From: Nicola Spencer
Sent: 06 November 2020 16:06
To: [REDACTED]
Cc: Iqraa Malik (iqraa.malik@terraquest.co.uk)
Subject: RE: Request for further information BR/207/20/HH

You need to quote the reference BR/207/20/HH

PROJECT	25 Havelock Road PO21 2EZ			CLIENT		Widt Nielson		
				Date	Issue Date	Scale (@ A3)		
SHEET	Block Plan			Drawn by	SW	DRAWING NUMBER		REV
				Checked by	SR	P106

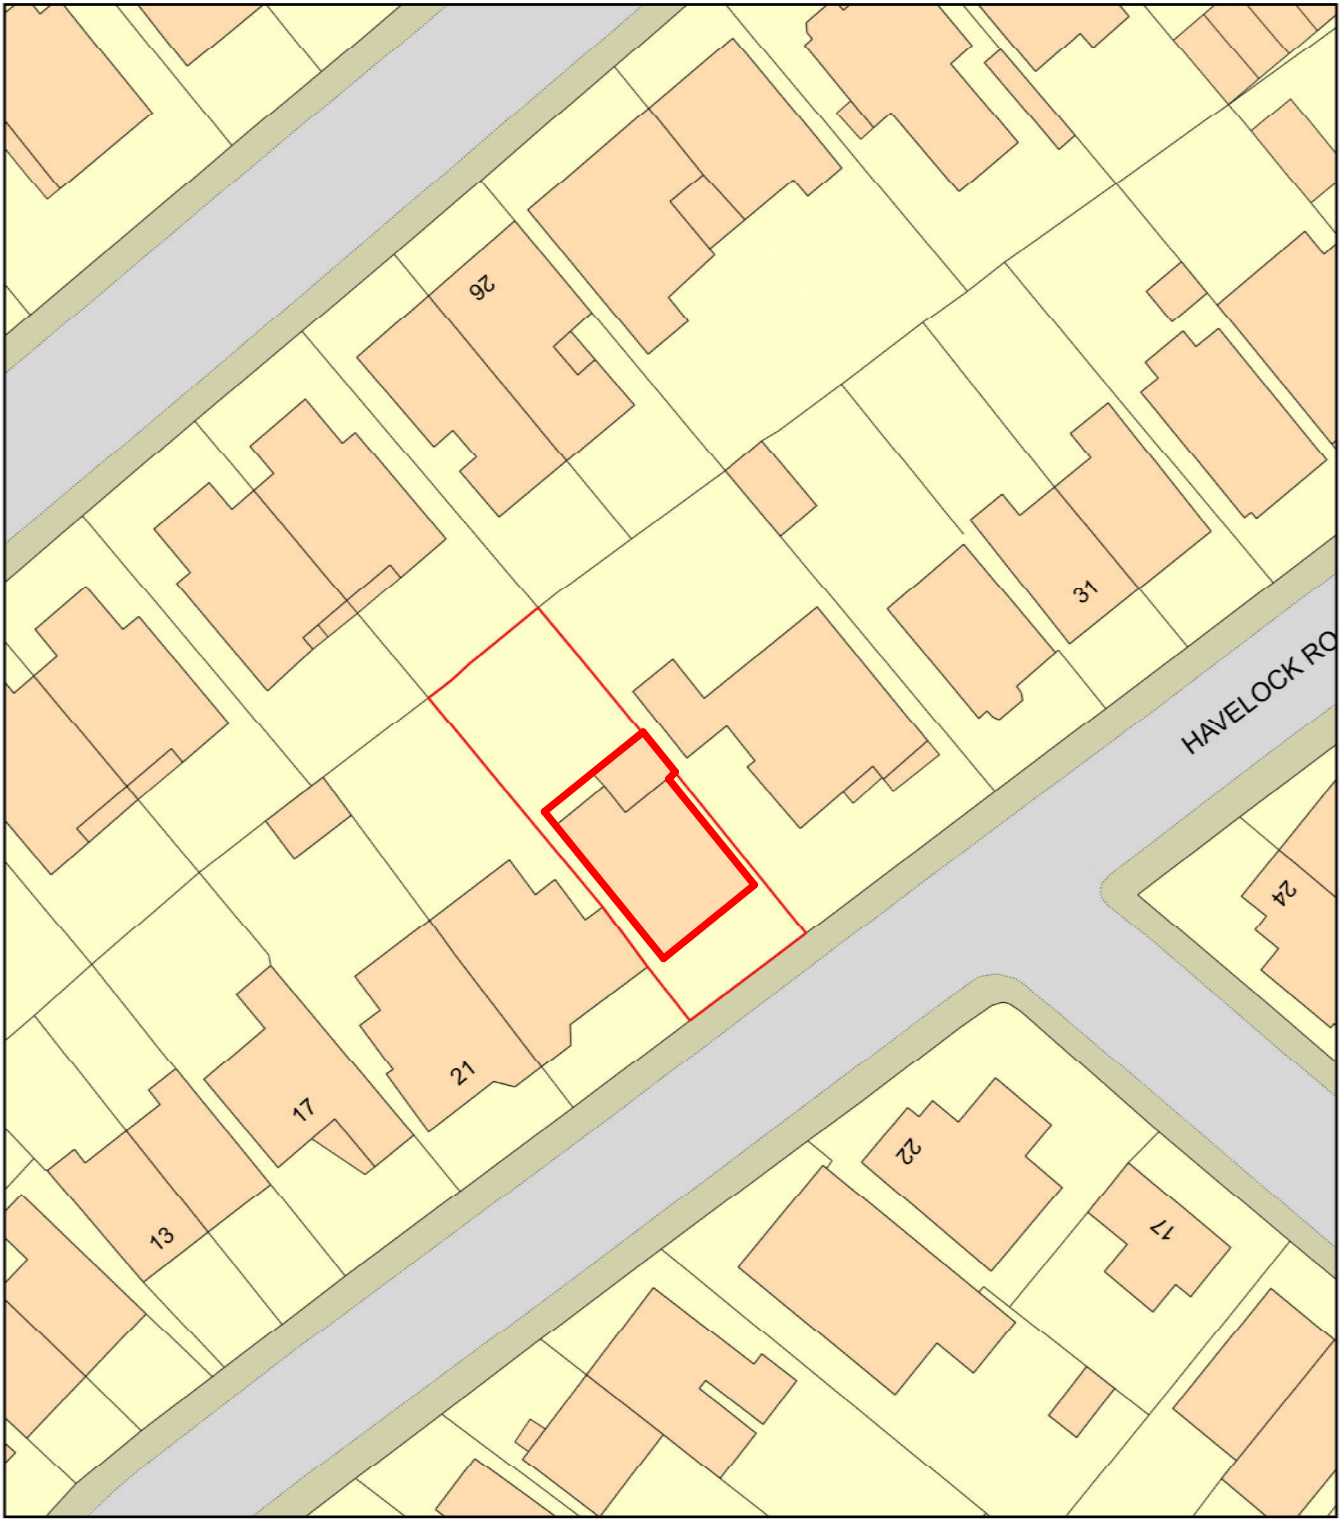
The plans Steve sent through this morning saved at A3 are now able to be measured to scale but on your scale bar on every plan, the scale for 1:500 is wrong. The block plan is correct in accordance with the OS scale bar but it is confusing to have their scale bar and your one on it when there is a difference between them. Please can the scale bar for 1:500 be corrected or removed from all of the plans. If this is done the plans are correct and can be accepted.
